## **North Wales Local Authorities Expert Topic Group's response to the SLVIA and LVIA submitted with the DCO application at the Deadline 1 stage of the Awel y Mor Offshore Wind Farm Proposal October 24 2022**

Please find below our collective response to the SLVIA and LVIA submitted with the DCO application for the proposed Awel y Môr Offshore Wind Farm (AyM OWF). Following an extension of a funding opportunity presented by RWE, the LUC was appointed once again by a group of seven North Wales Local Planning Authorities in August 2022 to undertake an updated review of SLVIA/LVIA matters with regards to the Awel y Môr Offshore Wind Farm (AyM OWF). The LUC had previously been appointed by the group in July 2021 to undertake a review during the PEIR stage, which was submitted alongside LPA comments during that time. The proposed wind farm comprises of onshore and offshore elements and potential effects resulting from these are reported separately. A copy of this report is included with this letter.

FIGURE TITLE:
Viewpoint 37 - Cefn Coch Stone Circle

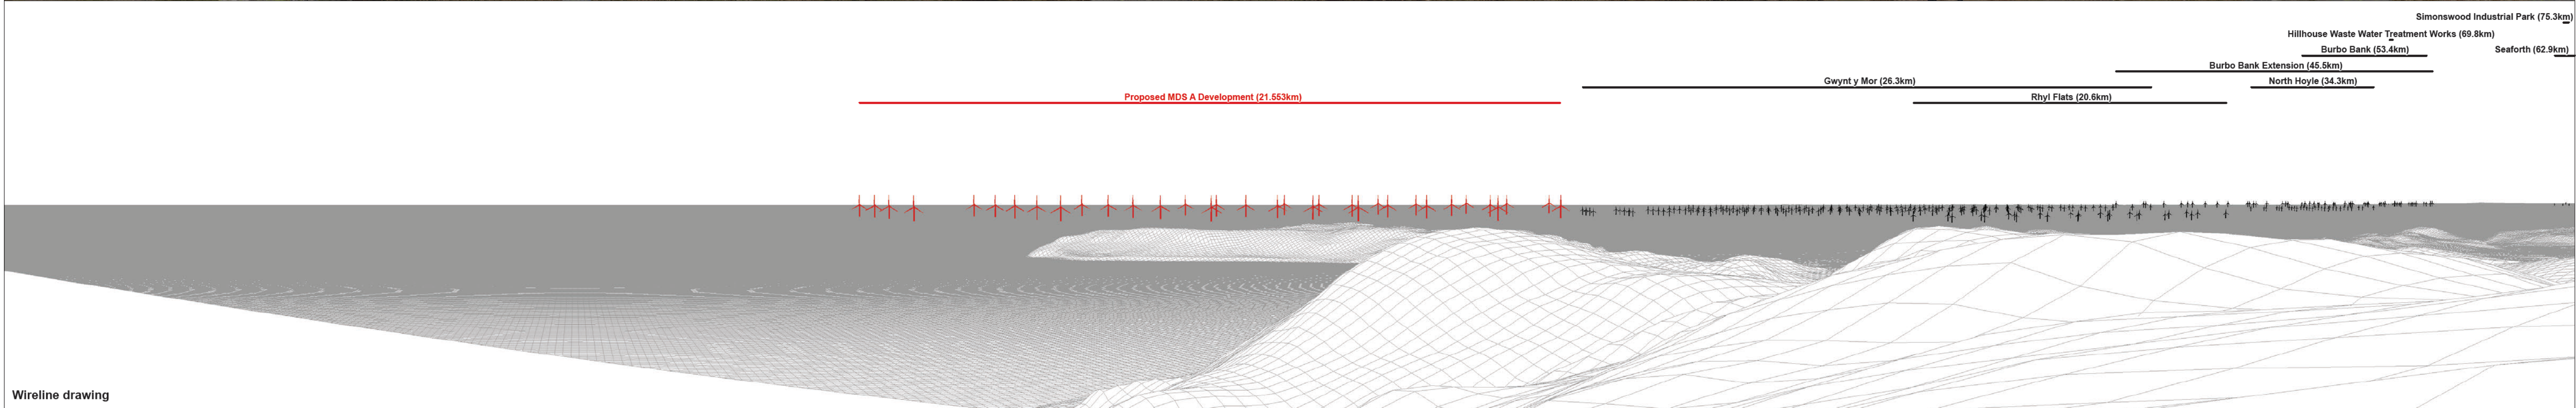
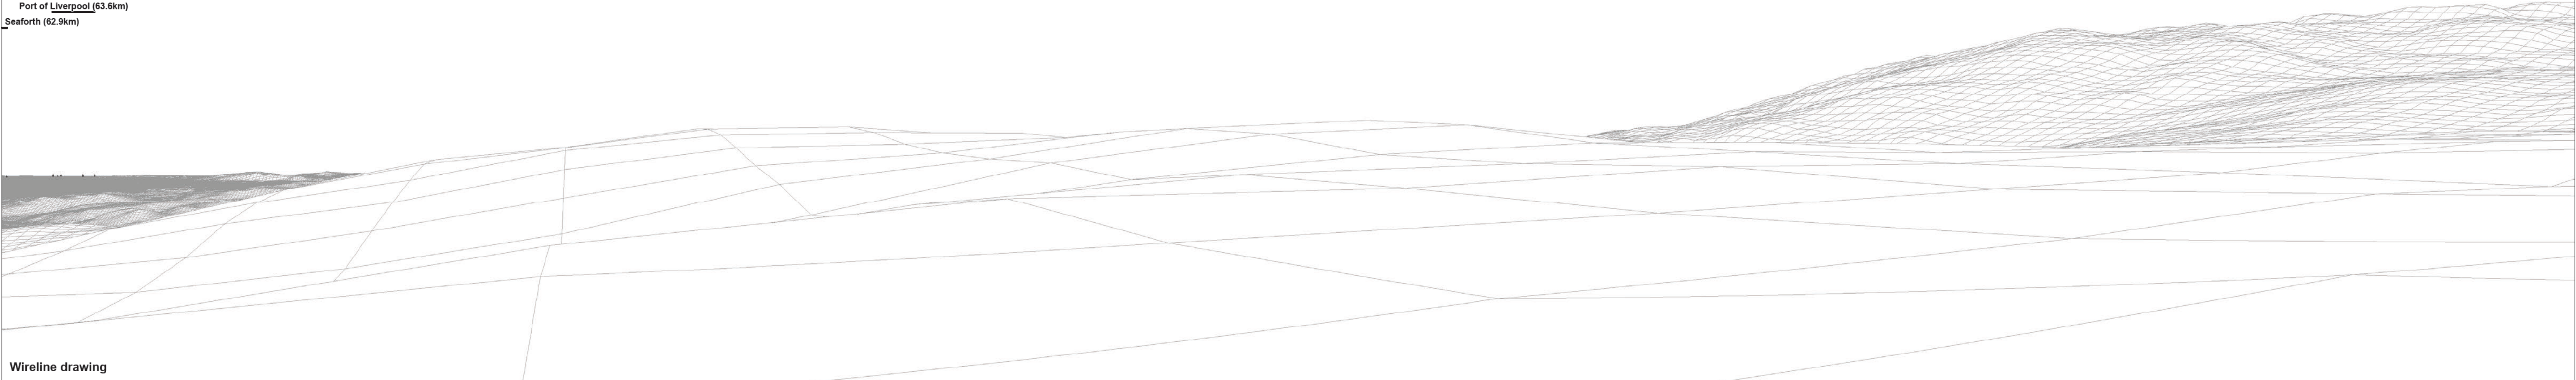
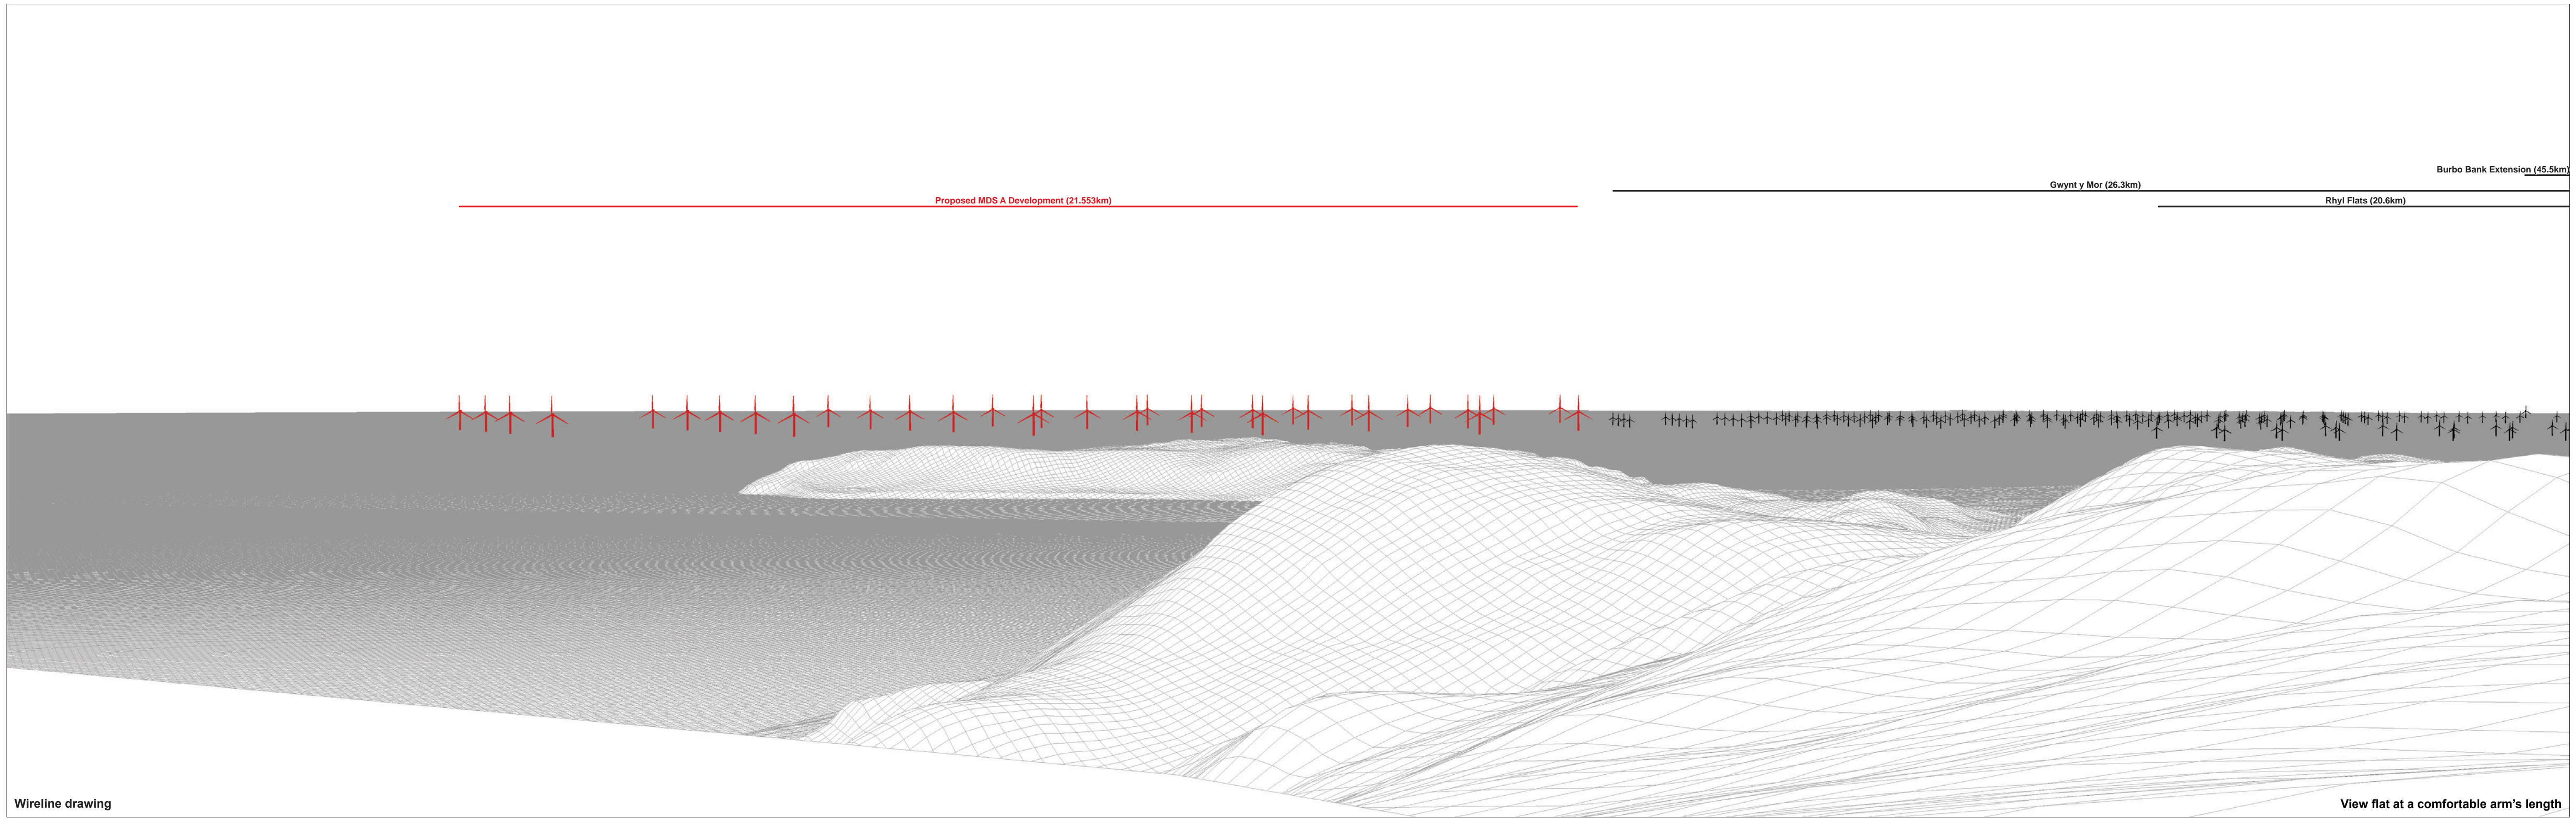
The impact of the AMOWF on the setting of views towards, and from, the Great Orme and Little Orme is illustrated in particular in the following images in the SLVIA:

Figure 64b: Cefn Coch stone circle (23.895km)

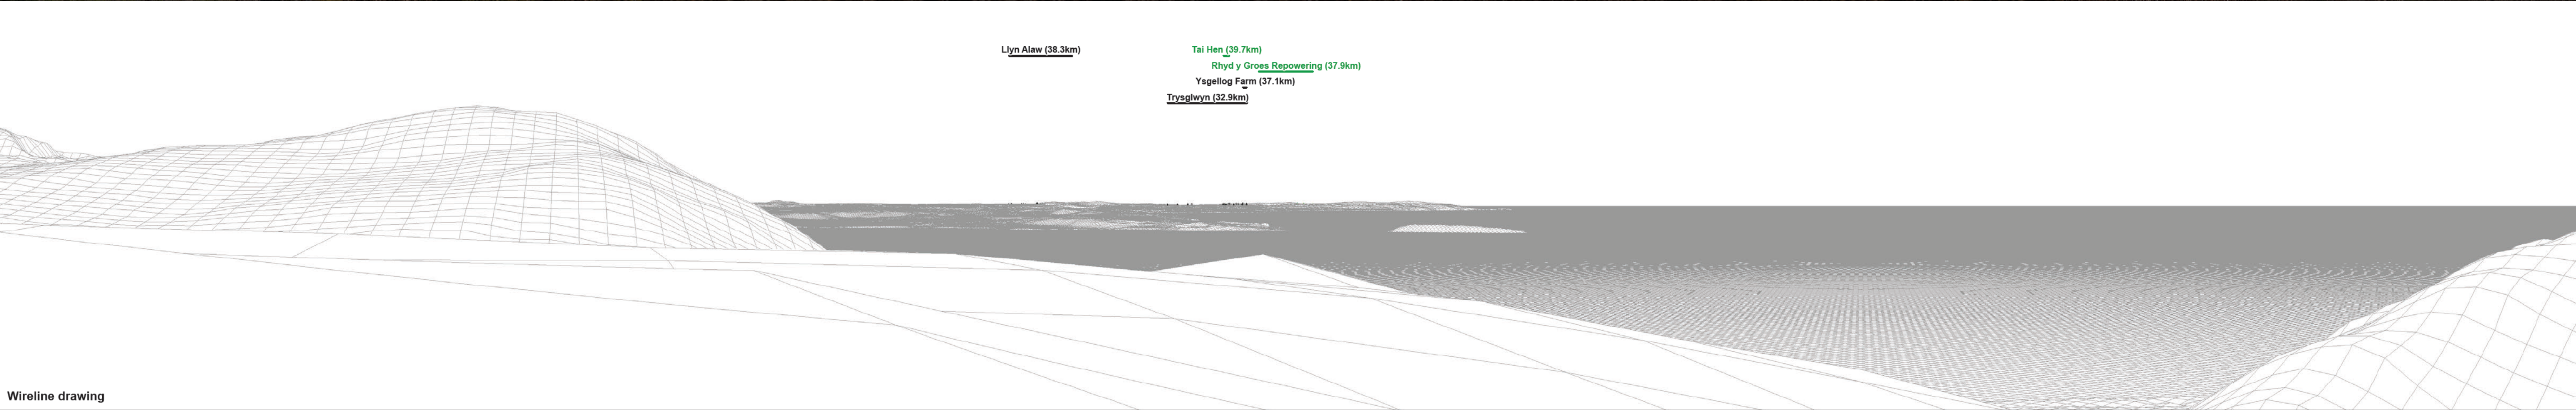
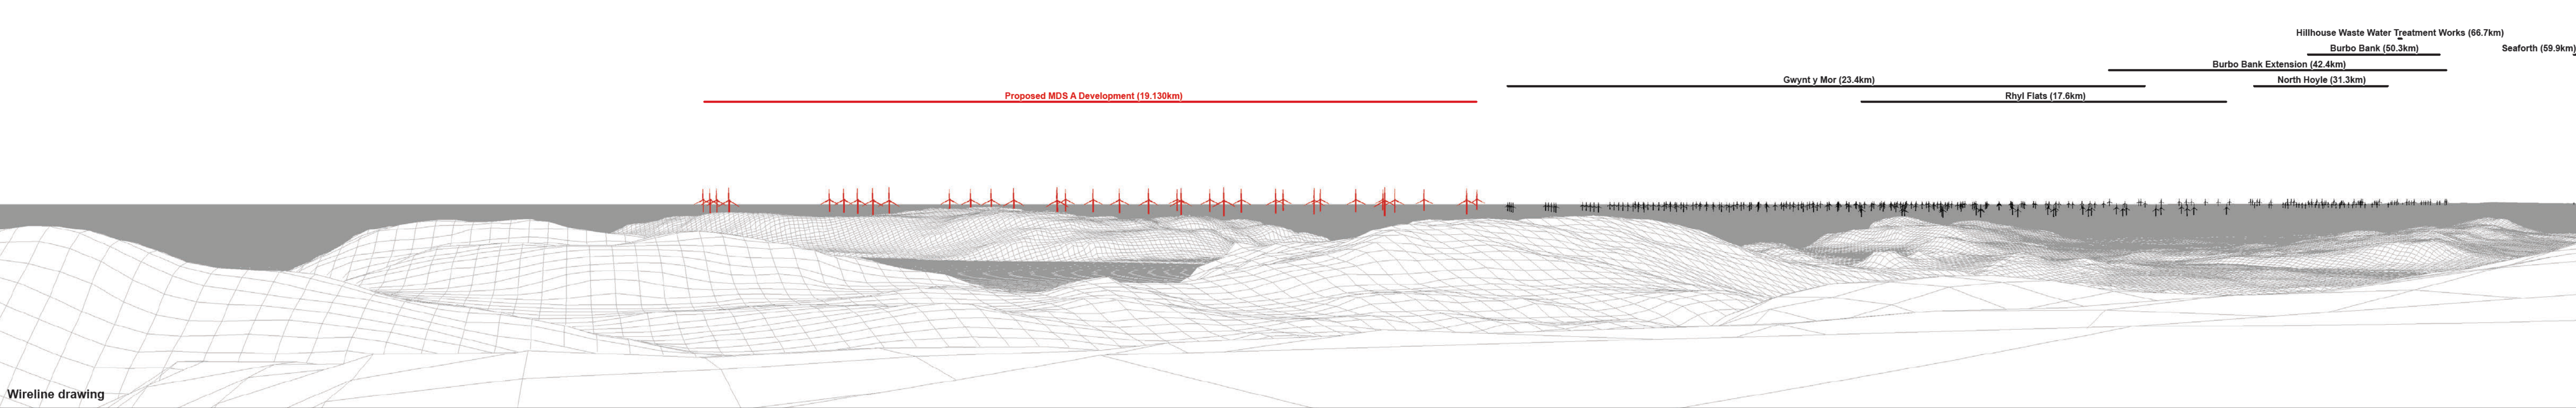
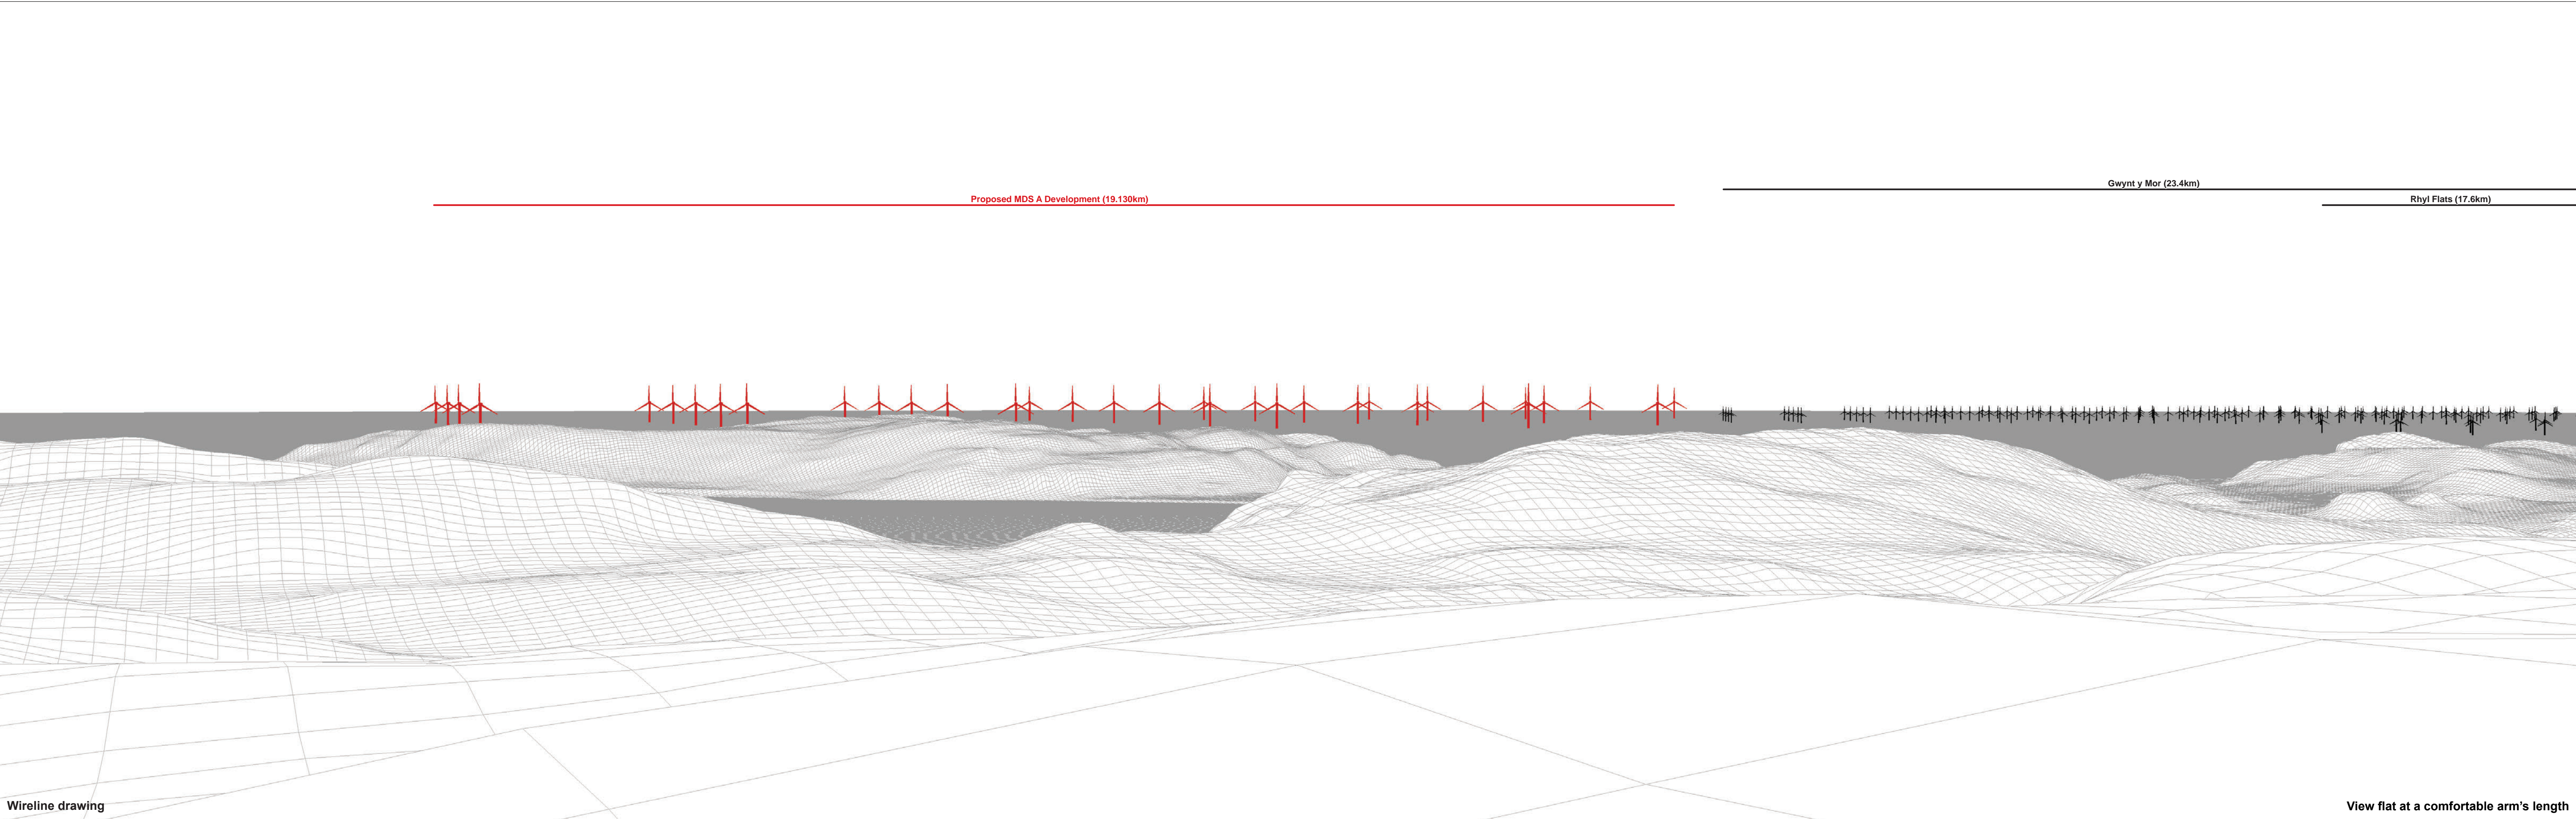
Figure 67c: Above Capelulo (19.13km)

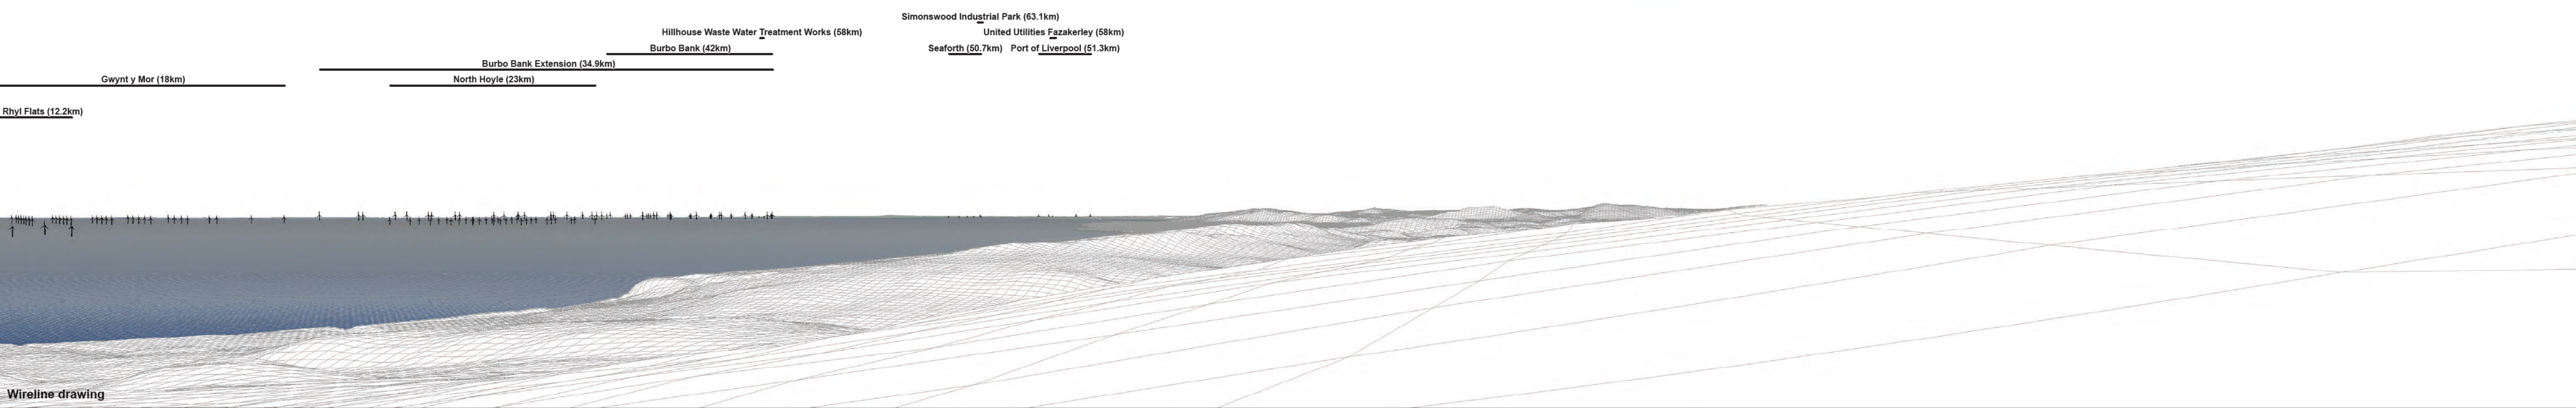
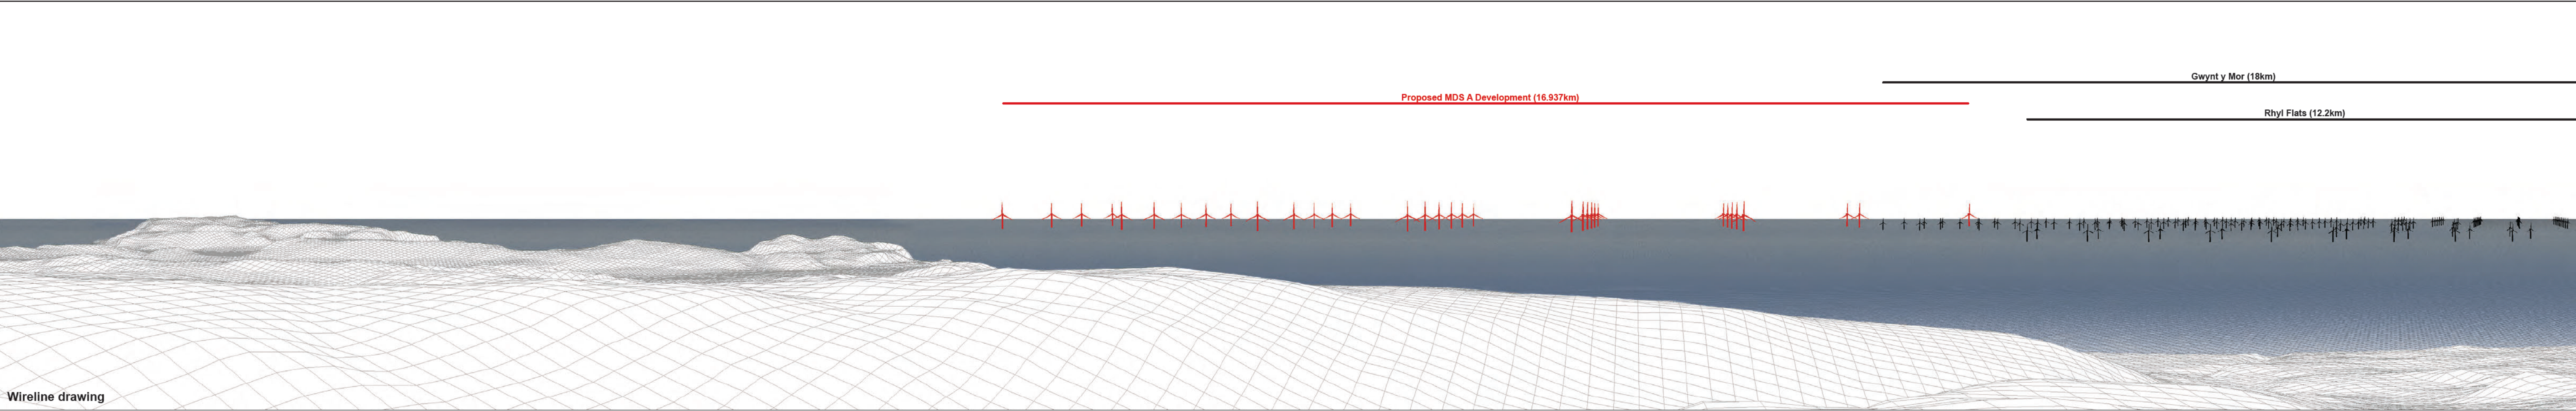
Figure 78b: Footpath above Cilgwyn Mawr (16.936km)
